Our ref: Newington College Redevelopment (Concept and Stage 1) (SSD-78268465)

Subject: Response to Submissions

I refer to the State Significant development application for the Newington College Redevelopment (Concept and Stage 1) (SSD-78268465) and the Department's Response to Submissions (RtS) letter dated 15 July 2026.

ATTACHMENT 1 KEY ISSUES / FURTHER INFORMATION REQUIRED

Basement Floor Plan

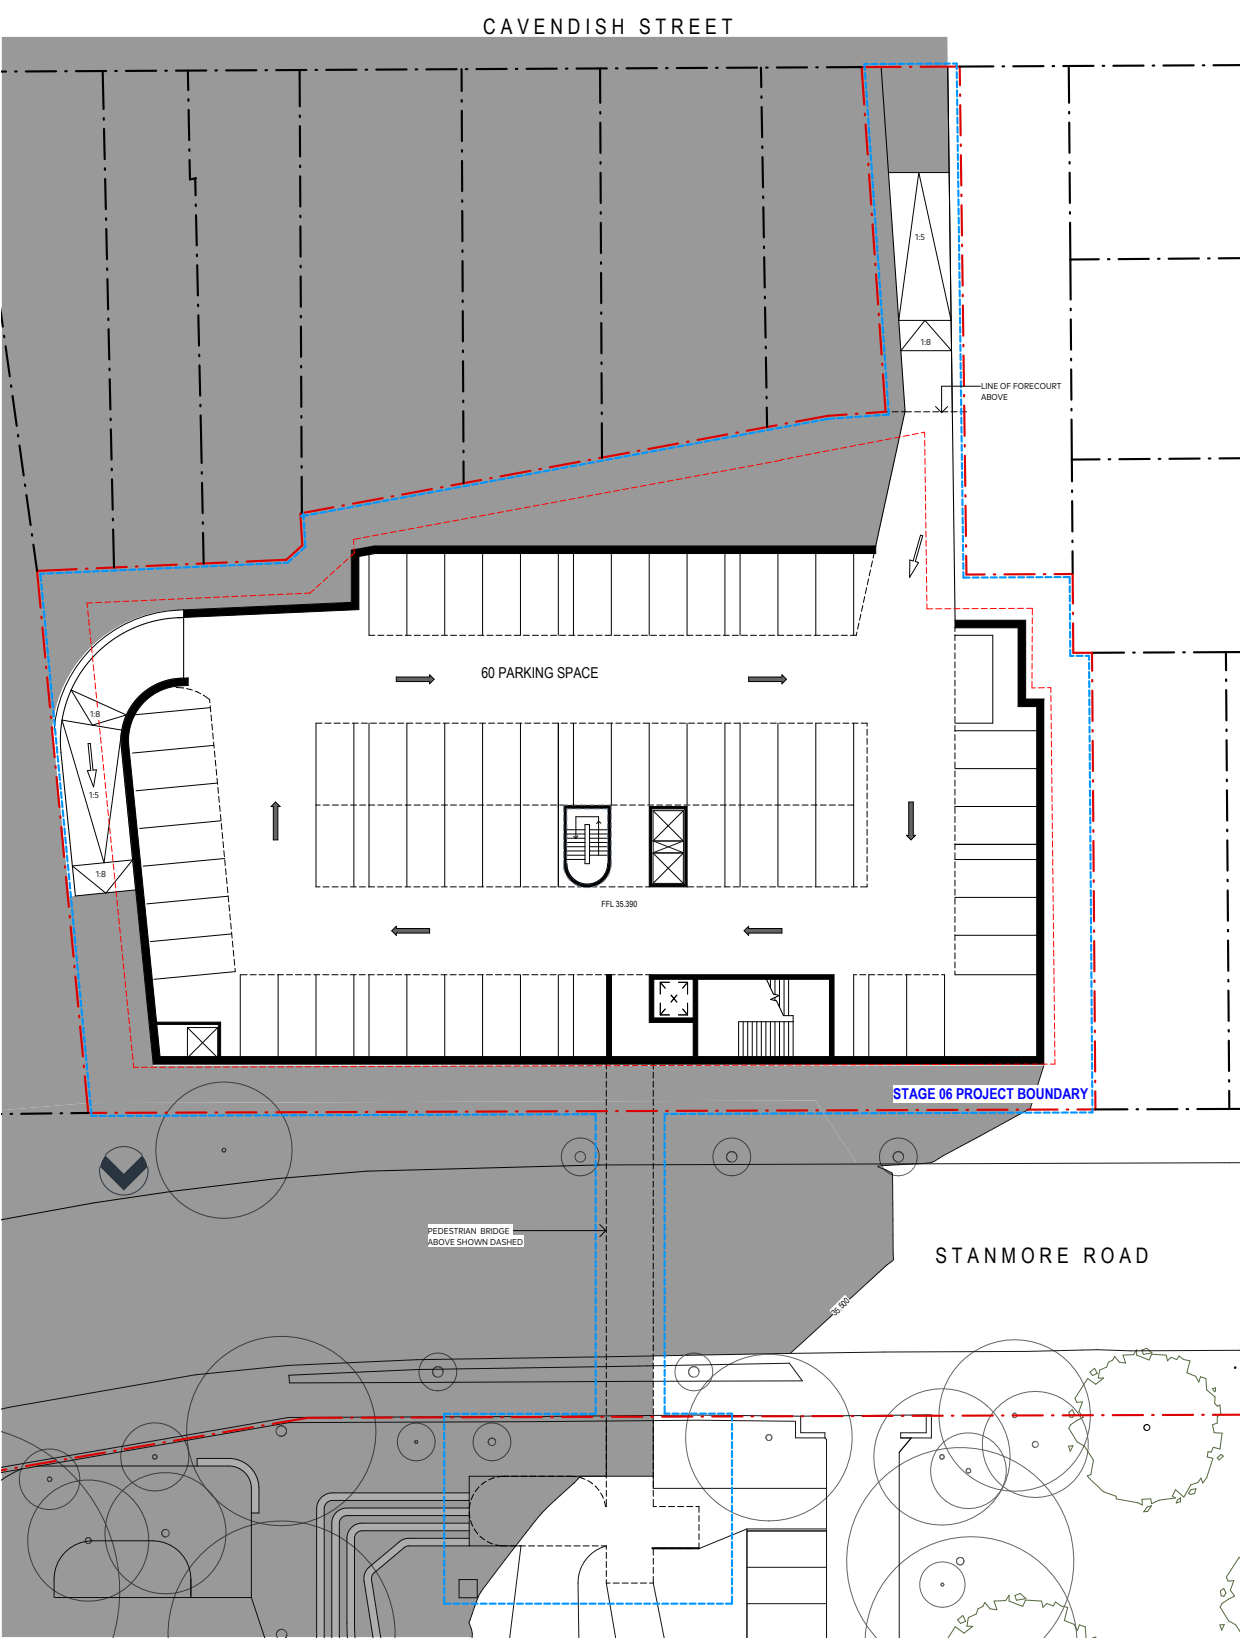
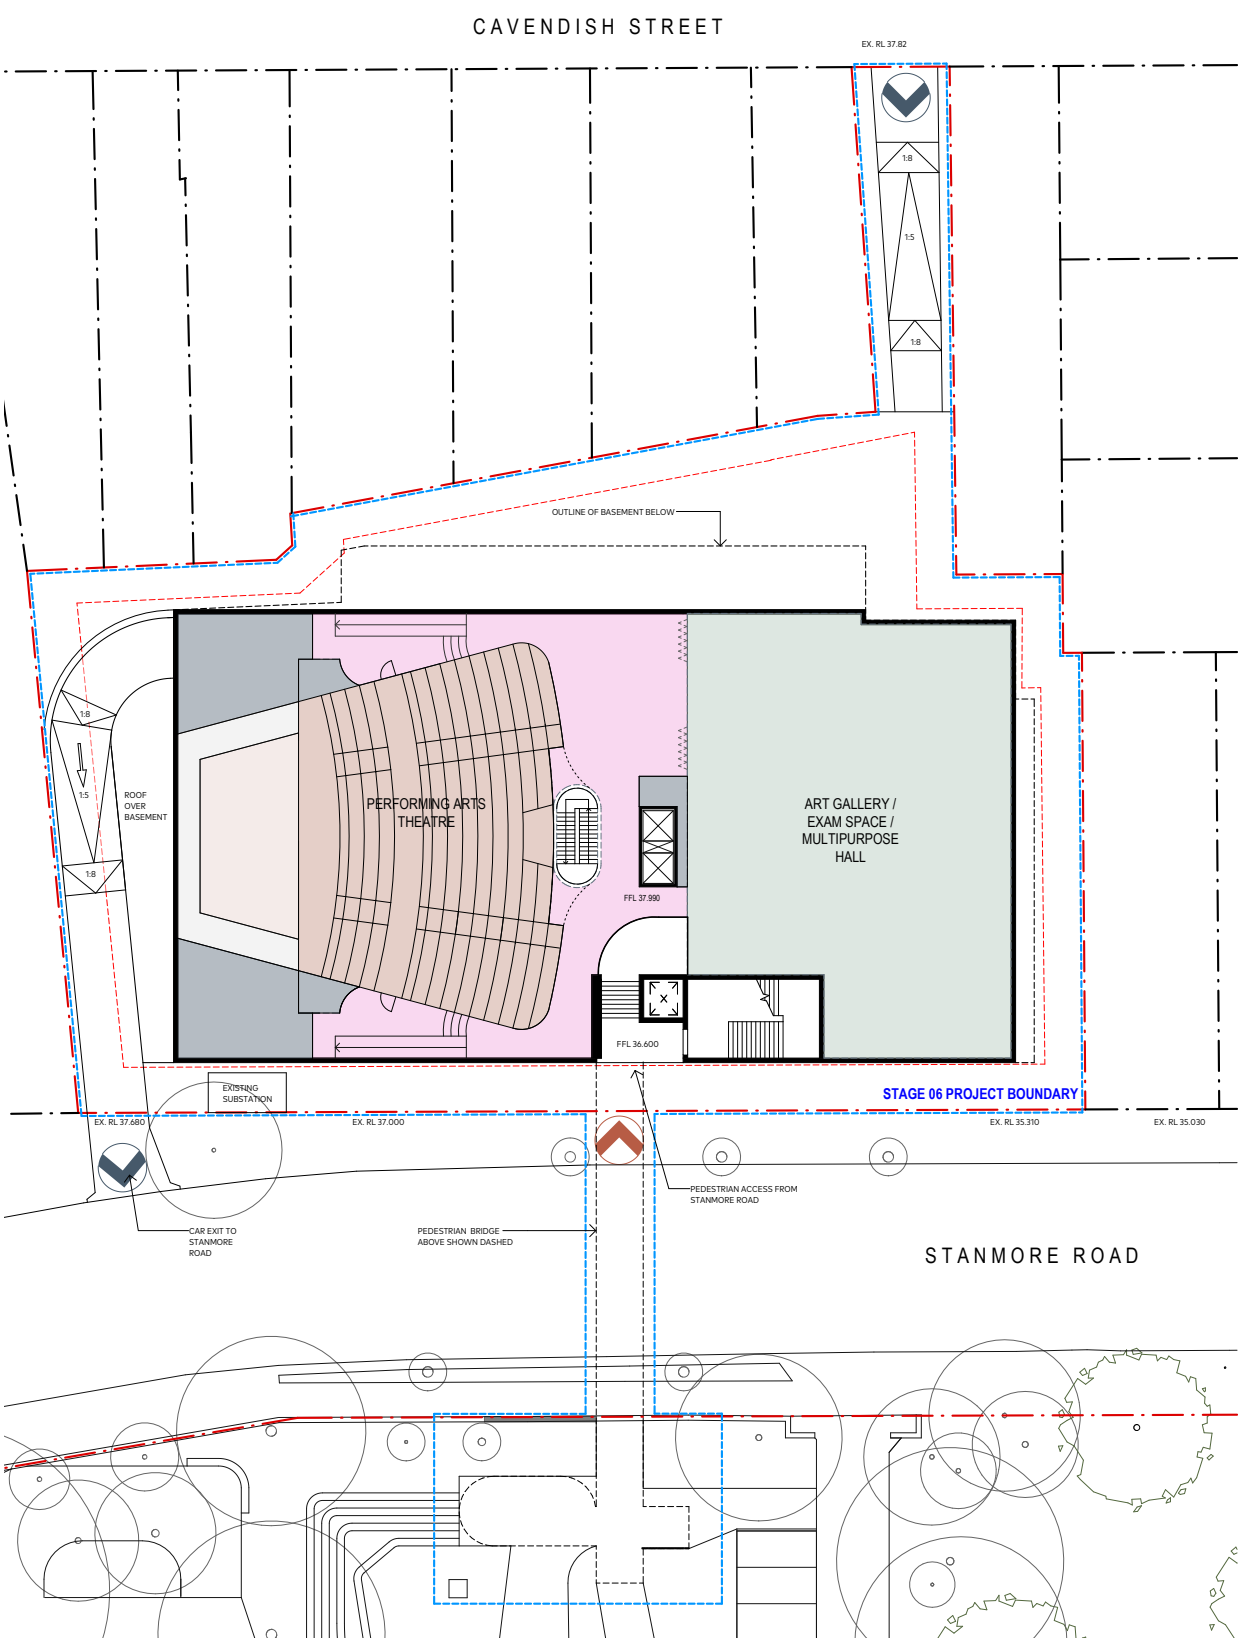
- the existing height, Gross Floor Area (GFA) and footprint of the Concordia Building
 - the proposed footprint of the Stage 6 Concordia Building envelope, noting inconsistencies between the architectural drawings and the overall concept site plan/staging plan

- Confirm and justify the proposed strategies regarding the enclosure of the Concordia basement access driveway, as recommended in the noise impact assessment, in order to mitigate noise impacts from vehicle access onto the adjoining residential dwellings.
